From: Laura Gibbons <Laura.Gibbons@arun.gov.uk>
Sent: 21 April 2021 14:33
To: Planning.Responses <Planning.Responses@arun.gov.uk>
Cc: Amy Myer <Amy.Myer@arun.gov.uk>
Subject: RE: Planning Consultation on: Y/43/21/DOC

Condition 7- surface water drainage

Application No:	Y/43/21/DOC
Registered:	25th March 2021
Site Address:	Land East of North End Road and West of Church Lane Nursery Yapton BN18 0GA
Description of Works:	Approval of details reserved by condition imposed under ref Y/18/20/PL relating to Condition Nos 4 - pre-commencement site meeting, 5 - contamination, 7 - surface water drainage and 8 - maintenance & management of surface water drainage.

NEW ACCESS ROAD & PARKING PERMEABLE
PAVING CONSTRUCTION
TYPICAL SECTION DETAIL

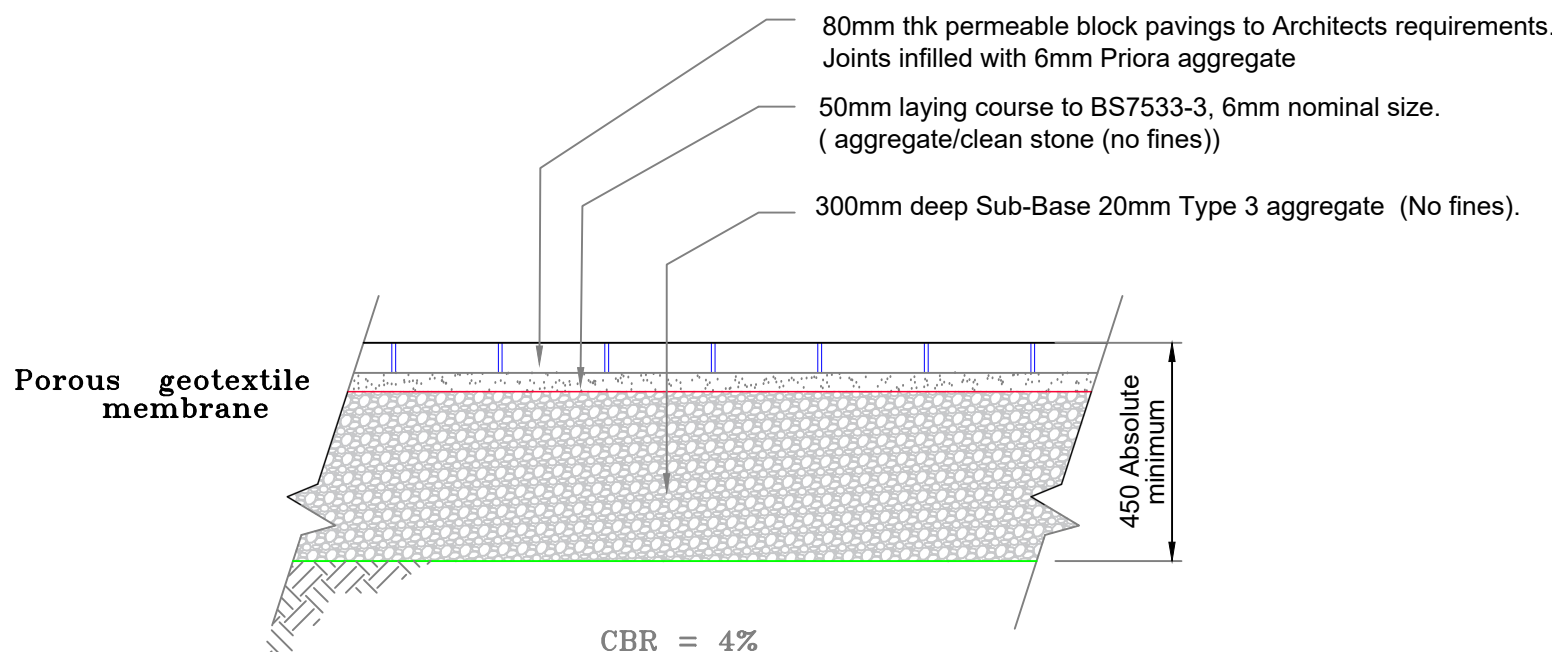
7. Please provide 1 in 10 year plus cc water levels and ensure that incoming invert levels to soakaways are above this level.
8. Construction detail drawings of permeable paving need to detail geotextiles.

TYPICAL SECTION
THROUGH
SOAKAWAY

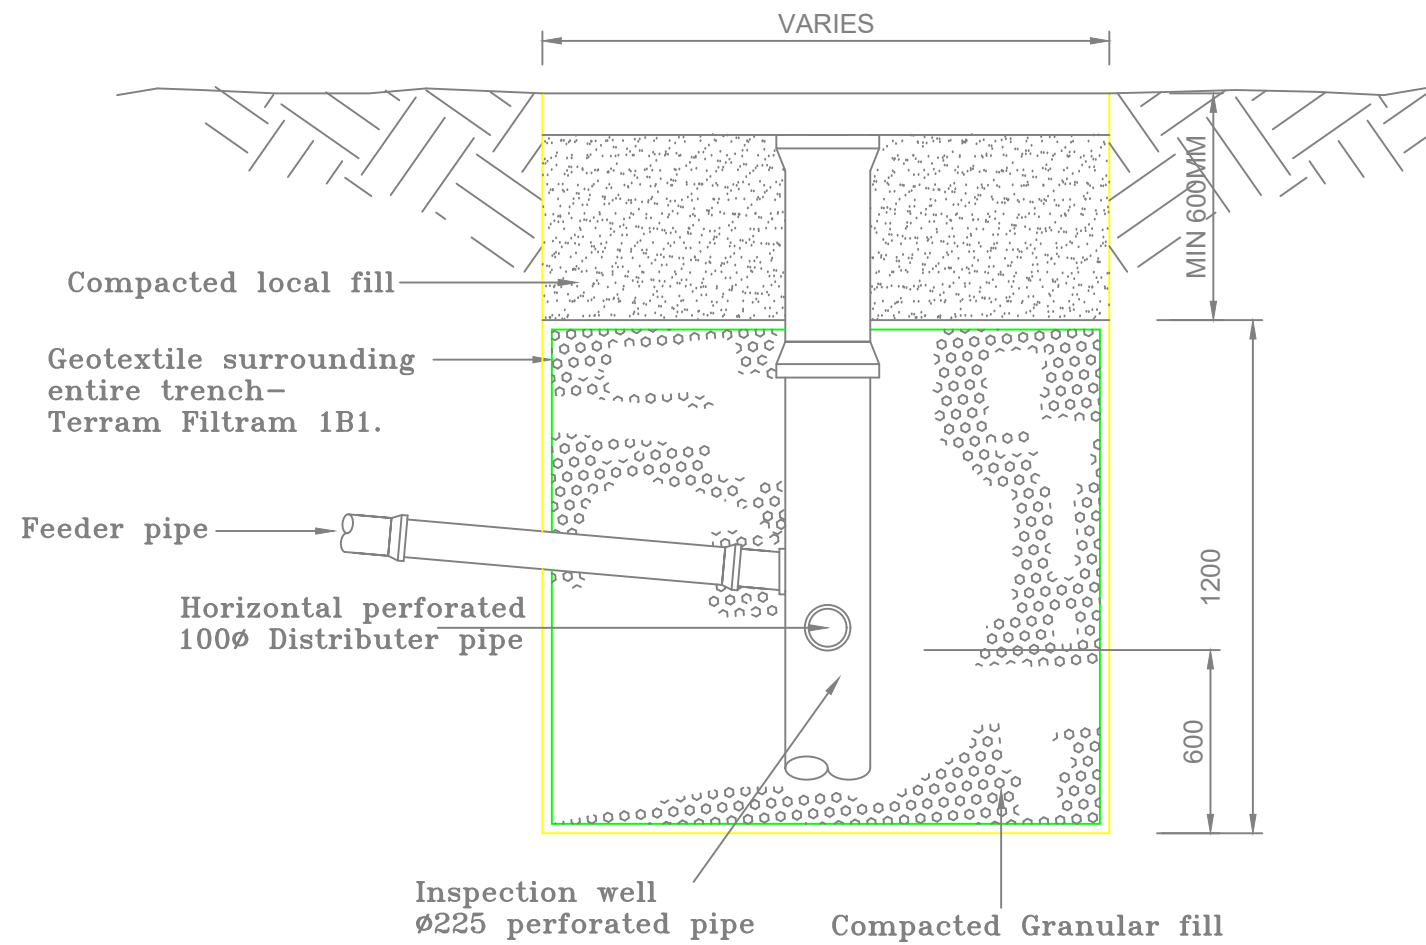
4. Layout plans show gravel filled soakaways right up to property boundaries. Soakaways should be located at least 5m from buildings and 2.5m from property boundaries.

5. It is not clear what factor of safety has been applied to design.
6. Please clearly label proposed soakaway dimensions on plan, i.e. invert level, depth, length, width, depth of cover above soakaway. It does not appear that calculated soakaway dimensions can be provided.

SOAKAGE TEST RESULTS

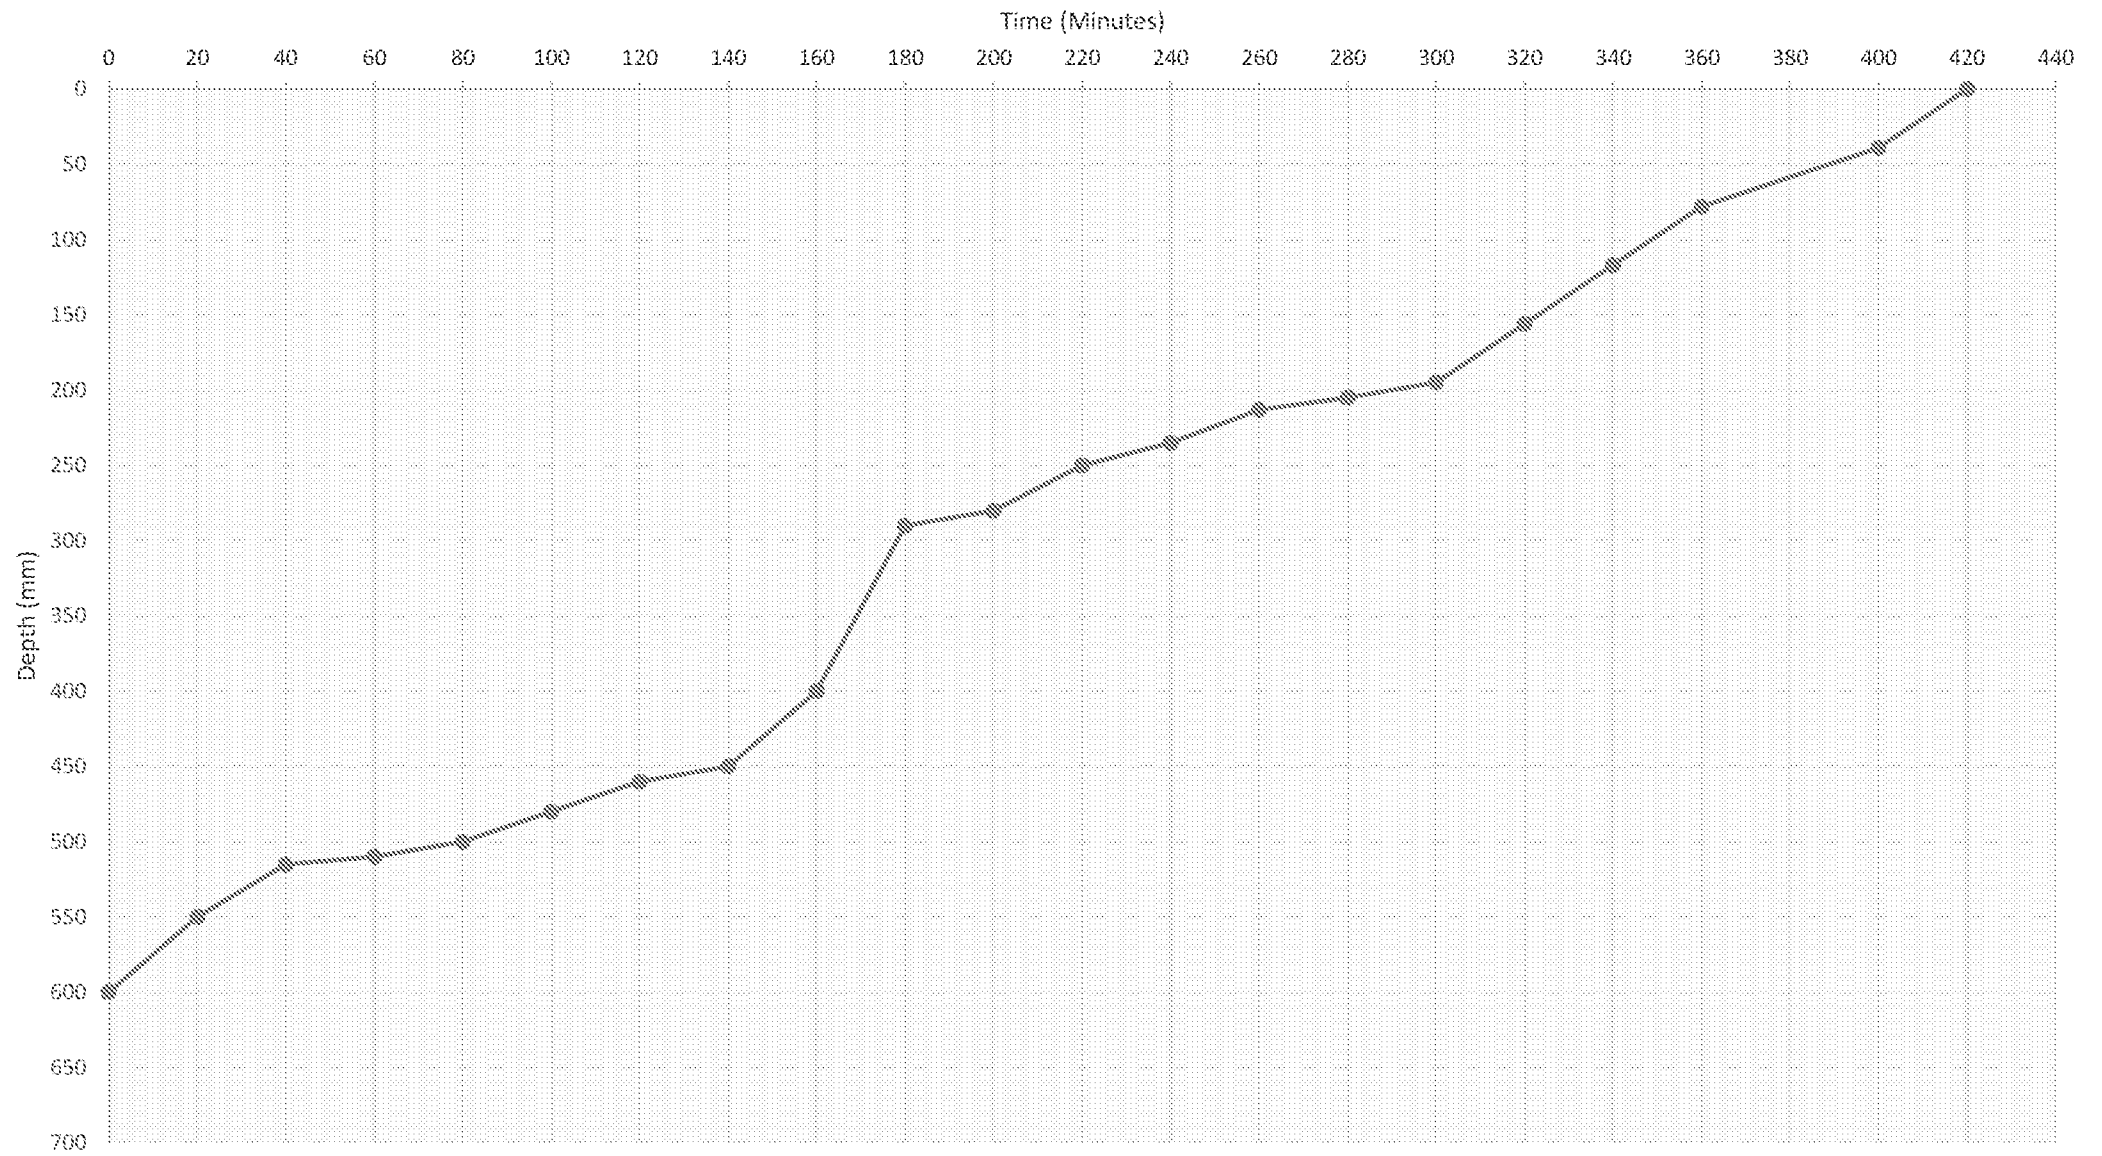
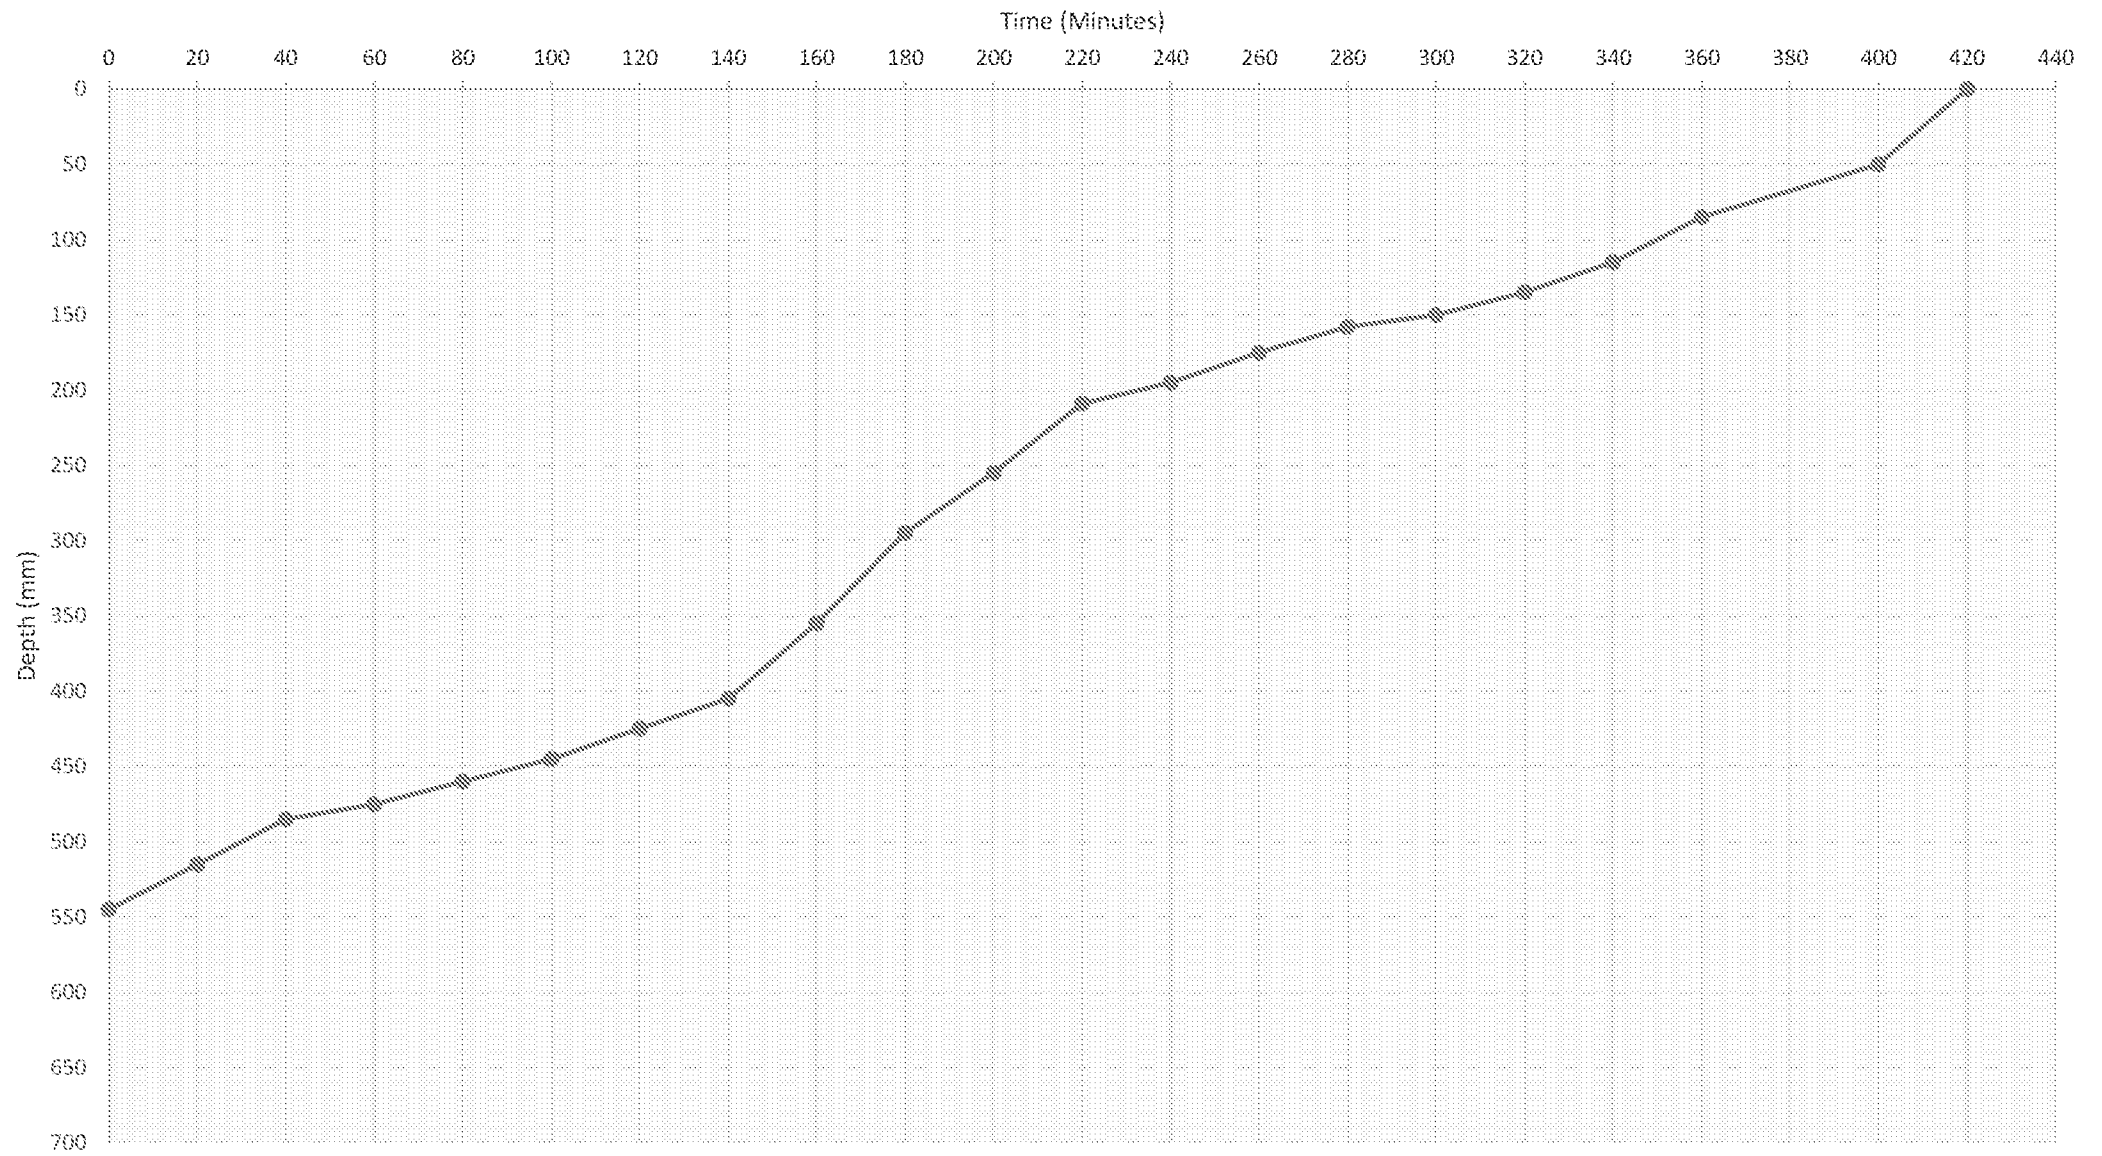
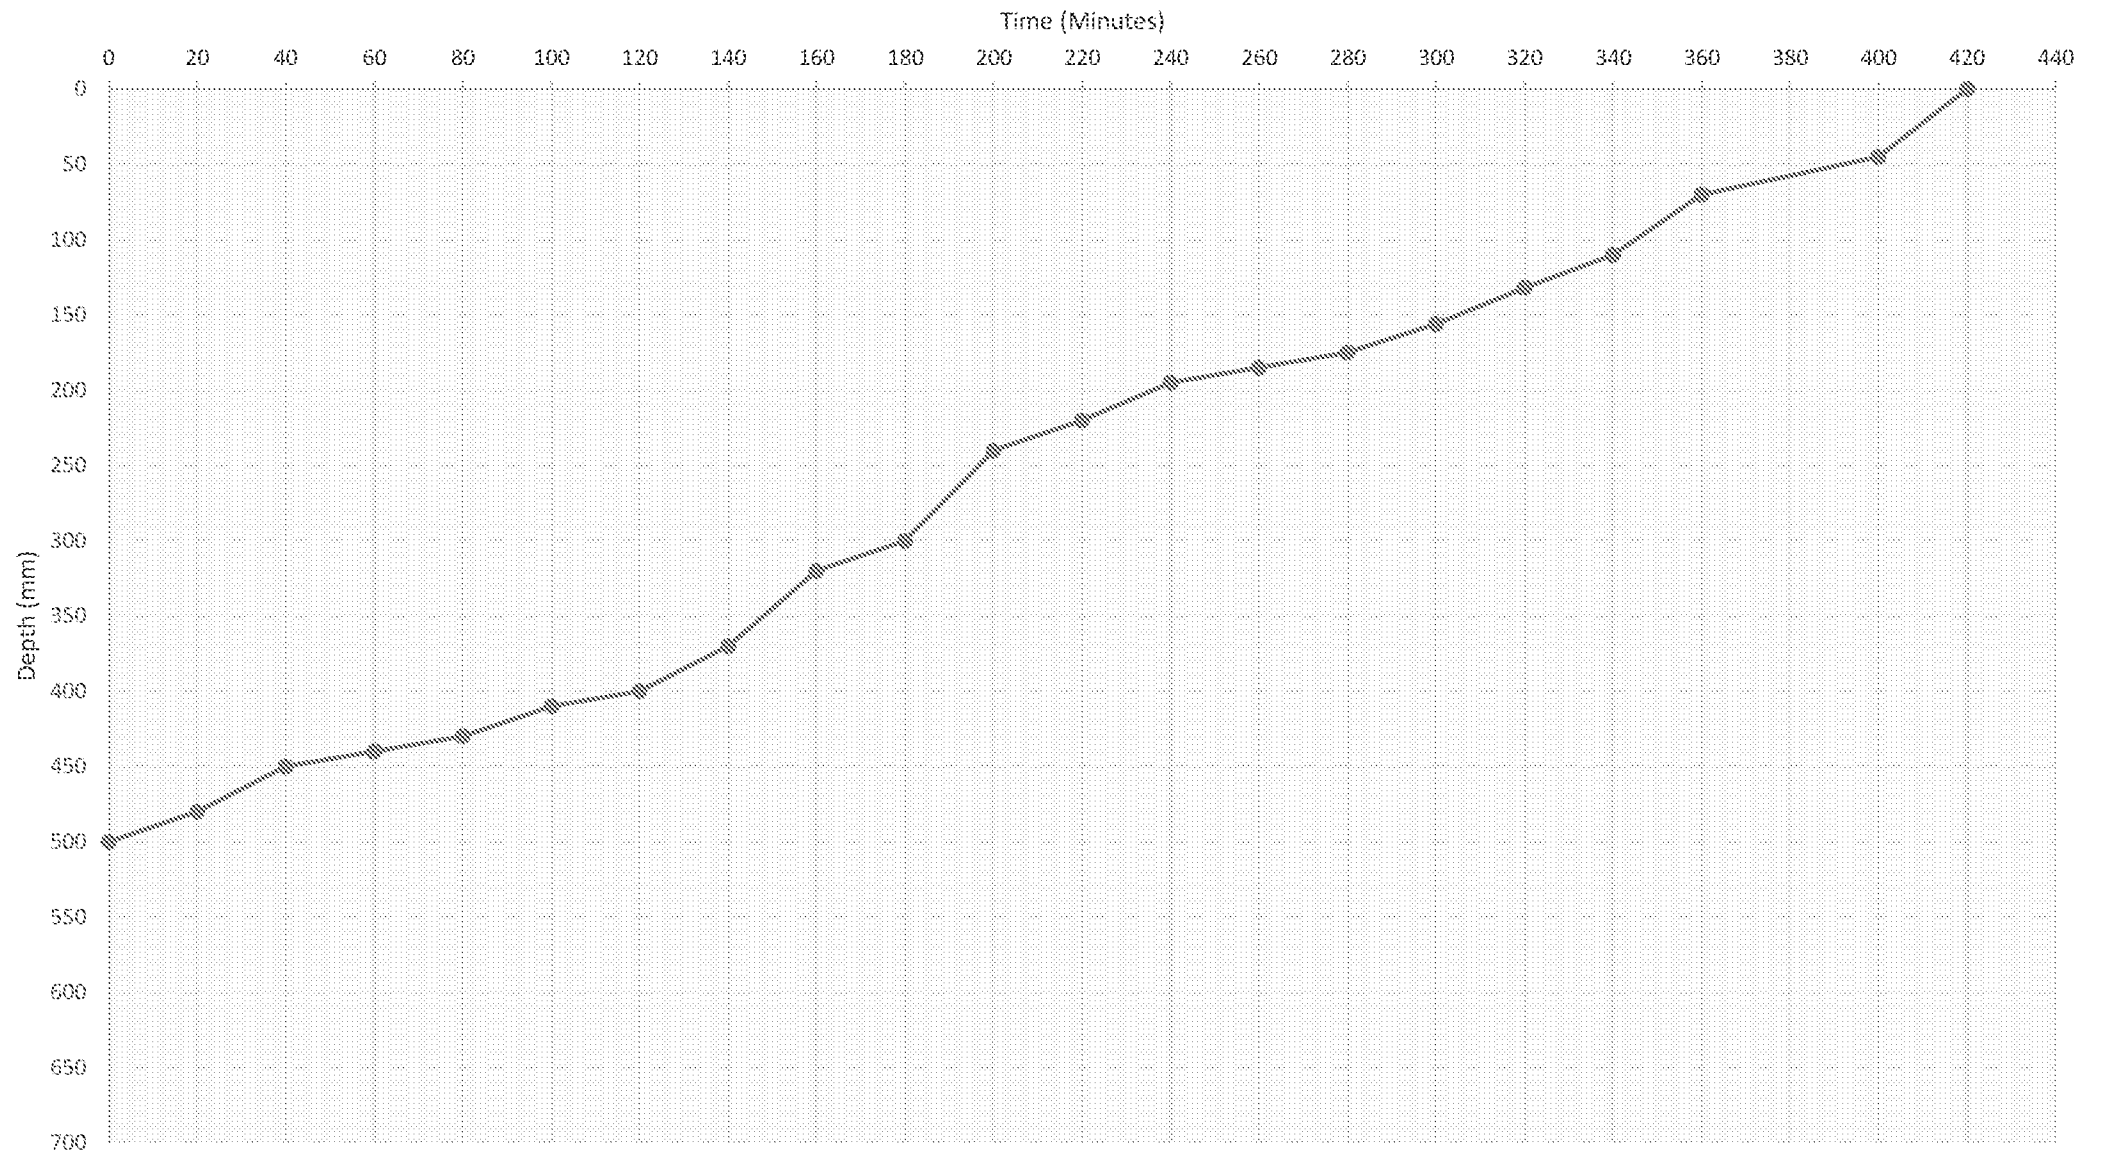
1. Please can the applicant confirm the date of infiltration testing.
2. Please submit results from winter groundwater monitoring.
3. Please supply an impermeable areas diagram which clearly shows the areas draining to each soakaway.
